**From:** Tim Screen  
**Sent:** 10 February 2023 18:24  
**To:** Wayne Campbell  
**Subject:** FW: 22/00747/OUT Land at Bicester Road, Kidlington

I provide the following response. Having considered the LVIA I find it comprehensive and adheres to the guidance of GLVIA3 and I tend to agree with its conclusions.

Figure 2.10: Proposed Bund Location

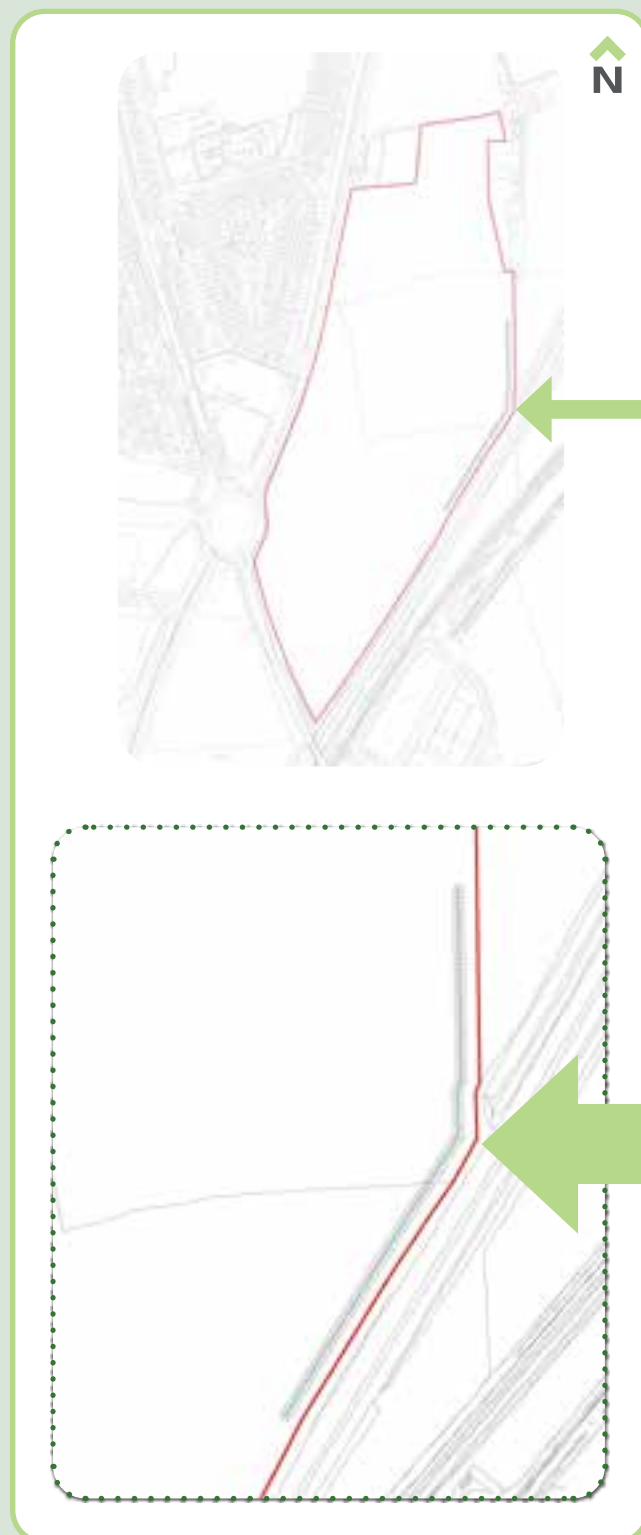
The bund with fence should be visually mitigated by native ticket.

Contractors vehicle access to repair the fence on top of the bund is necessary. The swale in front of it restricts access. A 3 m wide maintenance access along the entire length of the bund is important.

The material to build the bund may possibly come from the attenuation basins. The developer to clarify and confirm.

Details of the bunds construction and planting required under a planning condition.

Figure 4.3: Land Use Plan

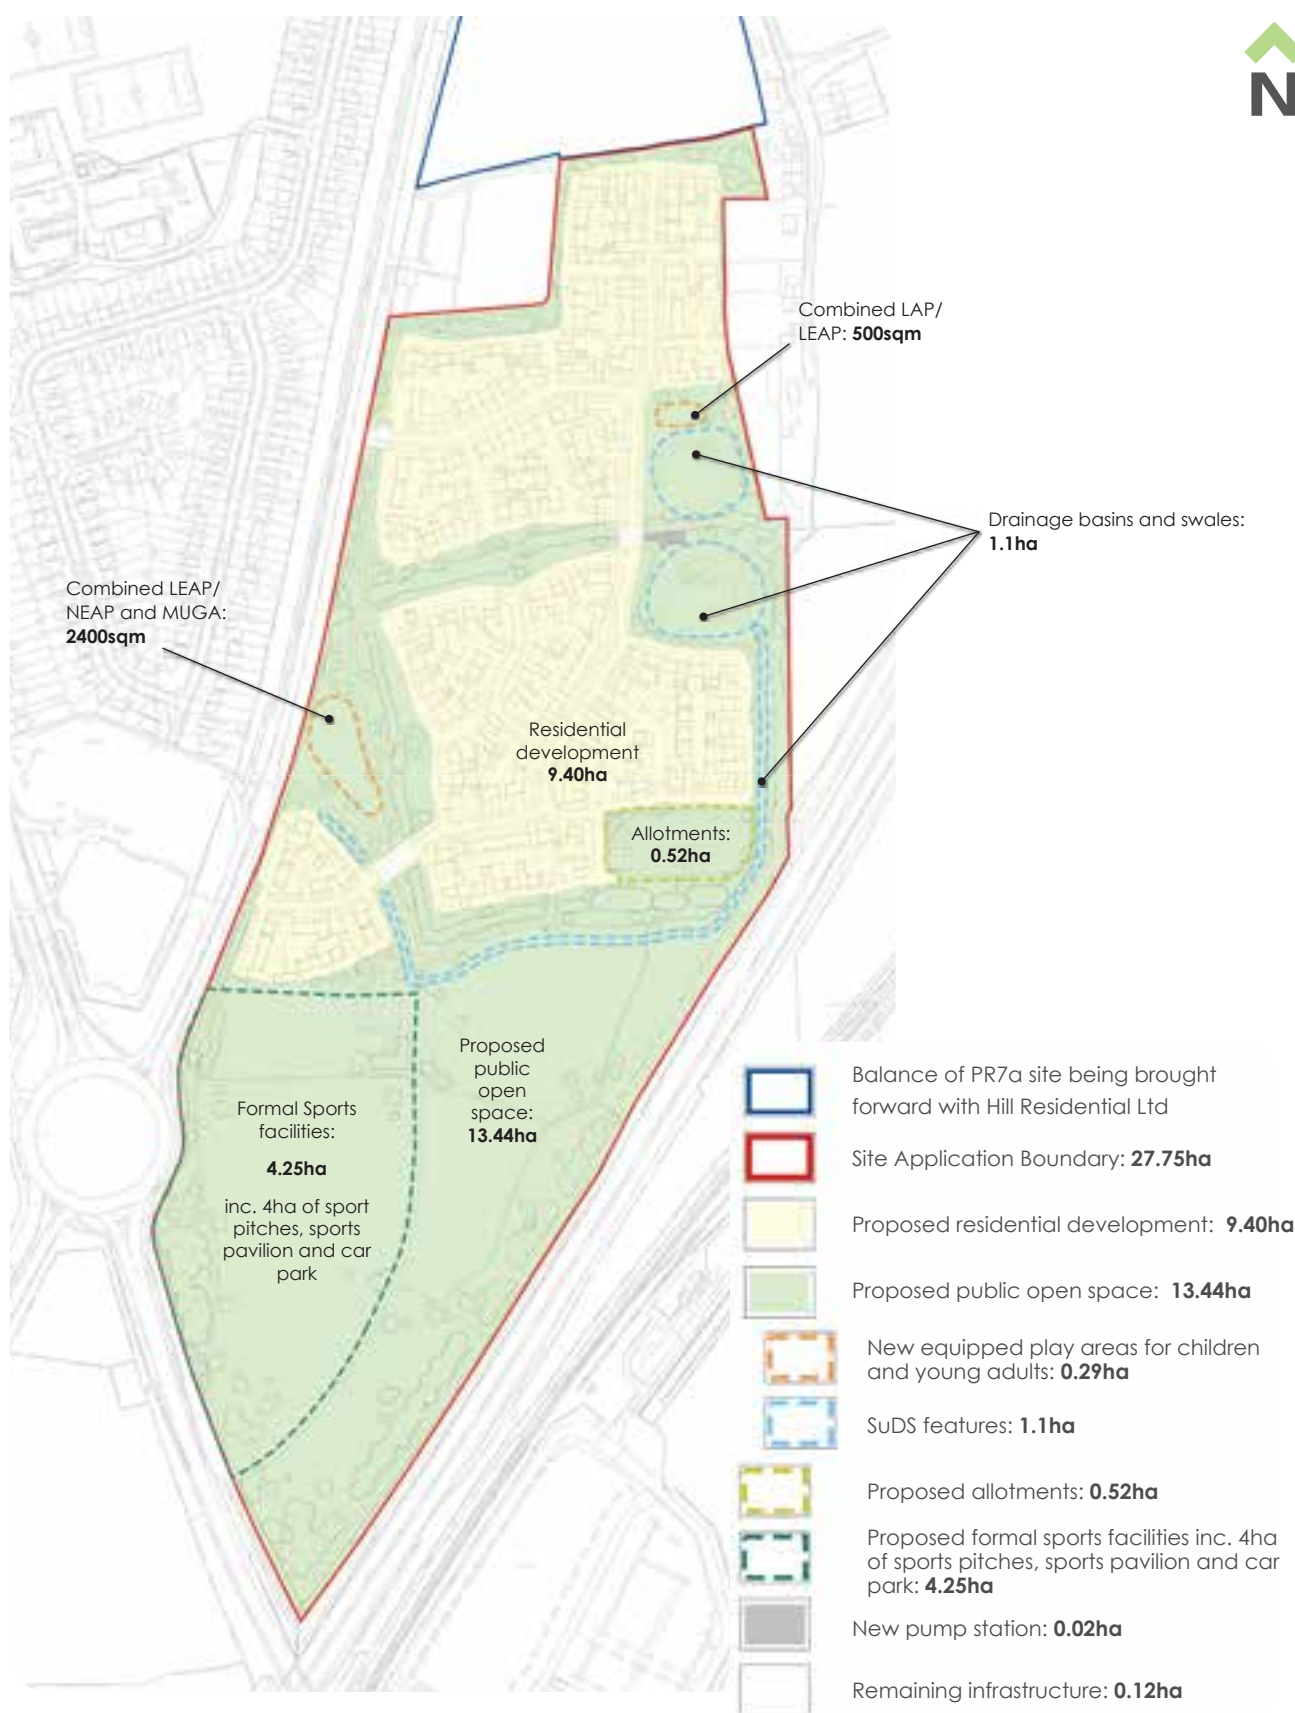
Because of the proposed location of the play area is close the pond with the disturbance to wildlife this there is also a potential risk of children drowning. Therefore I request that the play facility is located in the area currently proposed as a kick-a-bout.

The play area is to be located away from the SUDS basin for the safety of children. Is there to be standing water in the basin.

Firstly, having dealt with this application at the 'Unmet Housing'/design code stage I was always concerned that the pond habitat ecology was not adequately protected with the proposed LEAP/NEAP/MUGA Combined near the existing pond because the noise and disturbance will present quite an impact (and what about lighting?) I had requested a landscape buffer around the pond and the route diverted around this. The play facility relocated in the what is proposed as the kickabout area. The Kickabout area could be located further south.
